From: Katherine Rawlins
Sent: 25 November 2011 09:30
To: Planningecons
Subject: FW: AW/263/11/T The Water Tower 16 Craigweil Manor Aldwick PO21 4DJ

From: Ian Brewster
Sent: 24 November 2011 17:10
To: Katherine Rawlins
Subject: AW/263/11/T The Water Tower 16 Craigweil Manor Aldwick PO21 4DJ

South facing garden – Photos show excessive shading - taken from the house in the early afternoon at the beginning of August 2011.

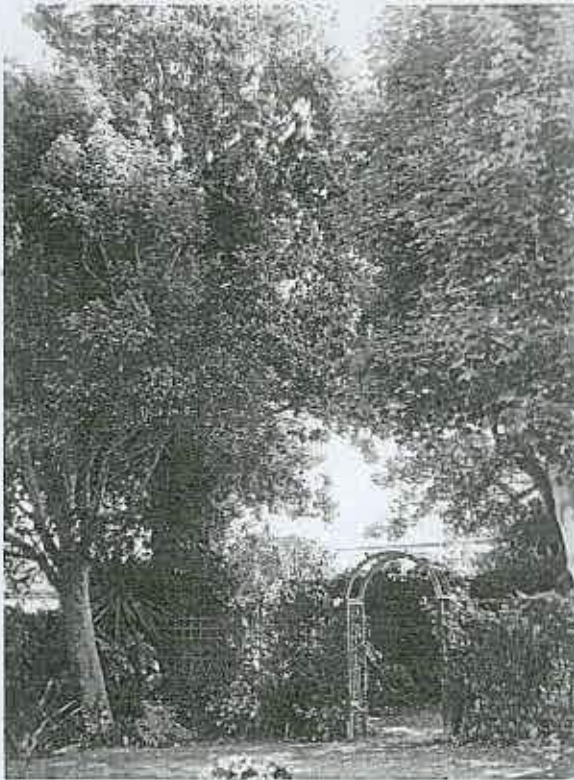
I accept the re-cutting of growths from the previously lopped Sycamore. there are other larger Sycamore trees which have been similarly treated and may require similar treatment due to weaker attachment points caused by their crown lopping. However the English Oak is a good tree and there is no discernable lopping points where a crown reduction of 25% could be cut back to without spoiling its overall natural aesthetic appearance. I feel this trees is an important amenity feature within the landscape and no Arboricultural justification exists for allowing the crown reduction to proceed.
